W SCC
County Planning – Minerals & Waste Planning Authority

CONSULTATION

TO:	Arun District Council Case Officer: Raymond Cole						
DATE:	2 April 2020						
LOCATION:	Ford Airfield, Ford						
SUBJECT:	F/4/20/OUT: Outline planning application (with all matters reserved except for access) for the development of up to 1,500 dwellings (Use Class C3), 60-bed care home (Use Class C2), up to 9,000 sqm of employment floorspace (Use Classes B1), local centre of up to 2,350 sqm including up to 900 sqm retail / commercial (Use Classes A1-A5) and 1,450 sqm community / leisure floorspace (Use Classes D1-D2), land for a two-form entry primary school (Use Class D1), public open space, allotments, new sports pitches and associated facilities, drainage, parking and associated access, infrastructure, landscape, ancillary and site preparation works, including demolition of existing buildings and part removal of existing runway hardstanding.						
RECOMMENDATION:

Figure 33: Outline Planning Application Parameter Plans - presented in detail on the following pages

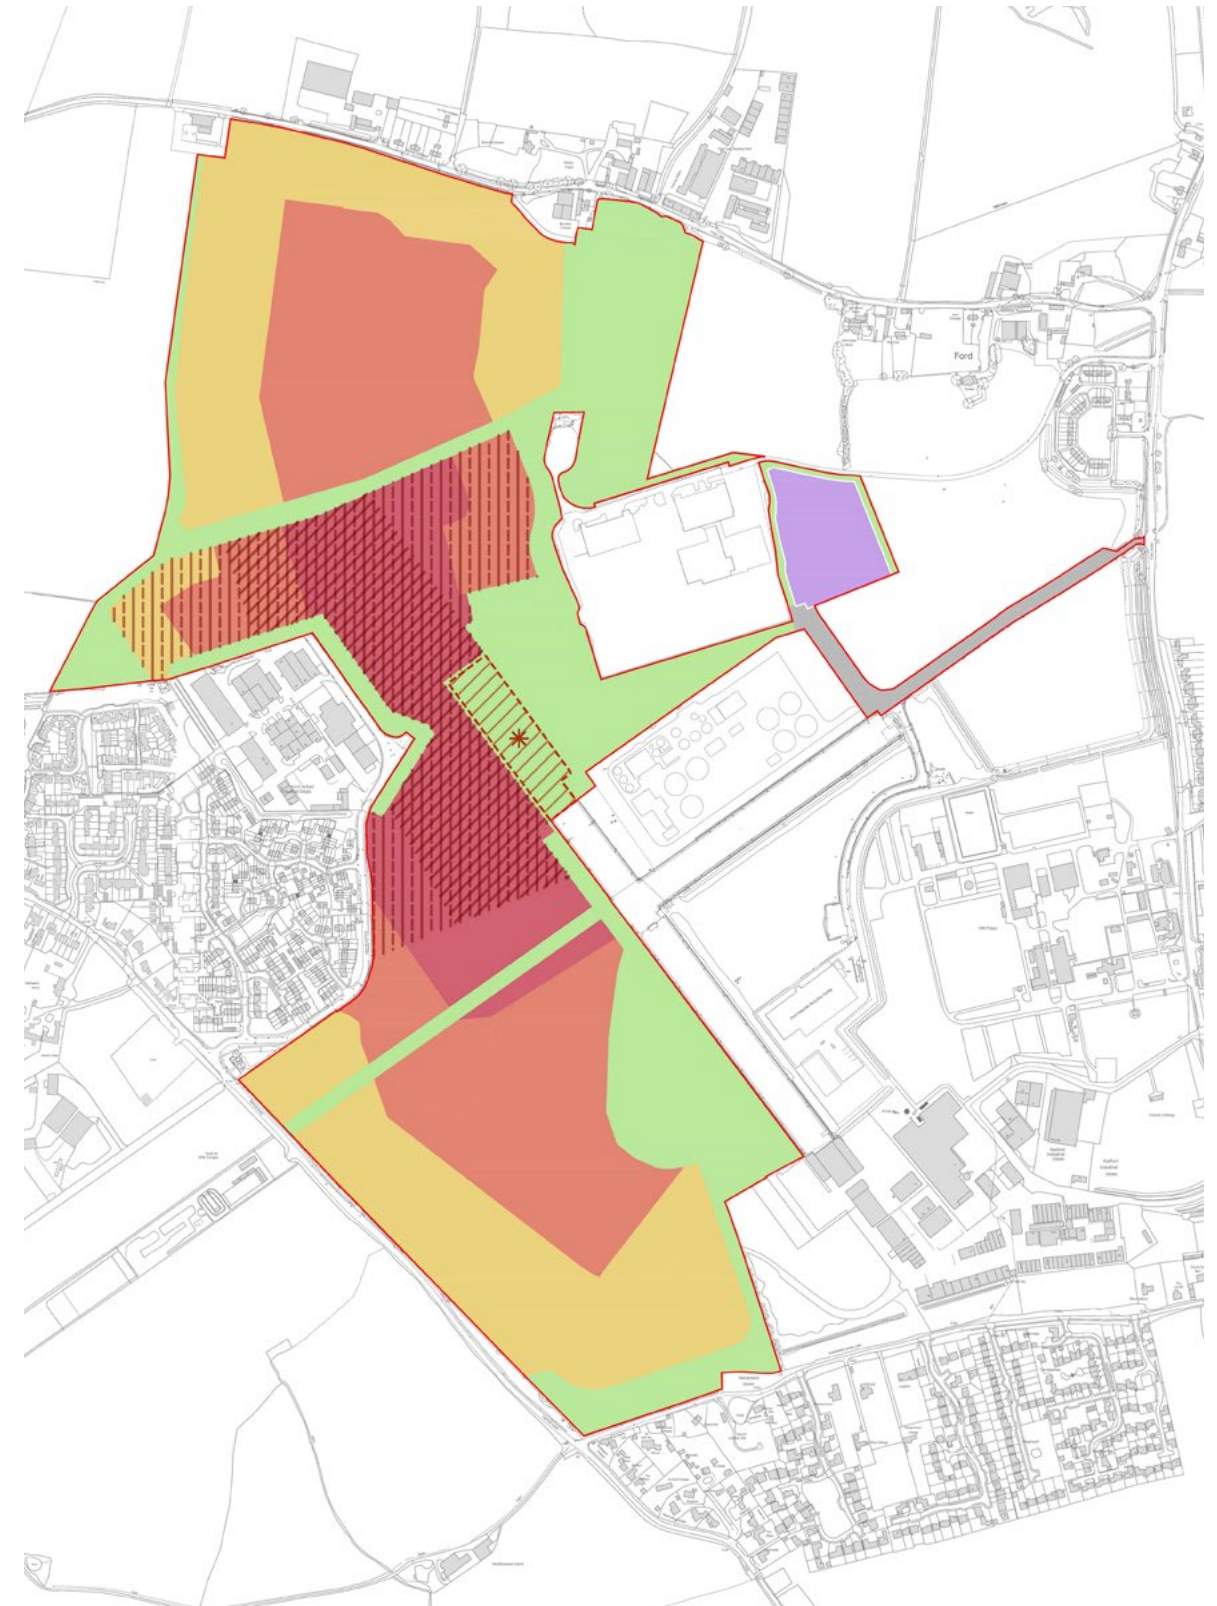
With reference to the submitted Masterplan (RG-M-78 Rev S) and Land Use plan (RM-M-123), of key concern at this stage is the proposed proximity of uses to the CTP including housing, the proposed 'local centre' to the west/north west, and the proposed employment uses immediately adjacent to the east. Given that this site is allocated as a strategic waste site, and planning permission has been granted, and part implemented, for an energy recovery facility, future operations are likely to have a greater impact than

is currently the case. The proposed uses are generally sensitive to the operation of a waste facility, are much closer than any existing receptor, but no details of potential impacts or proposed mitigation has been provided.
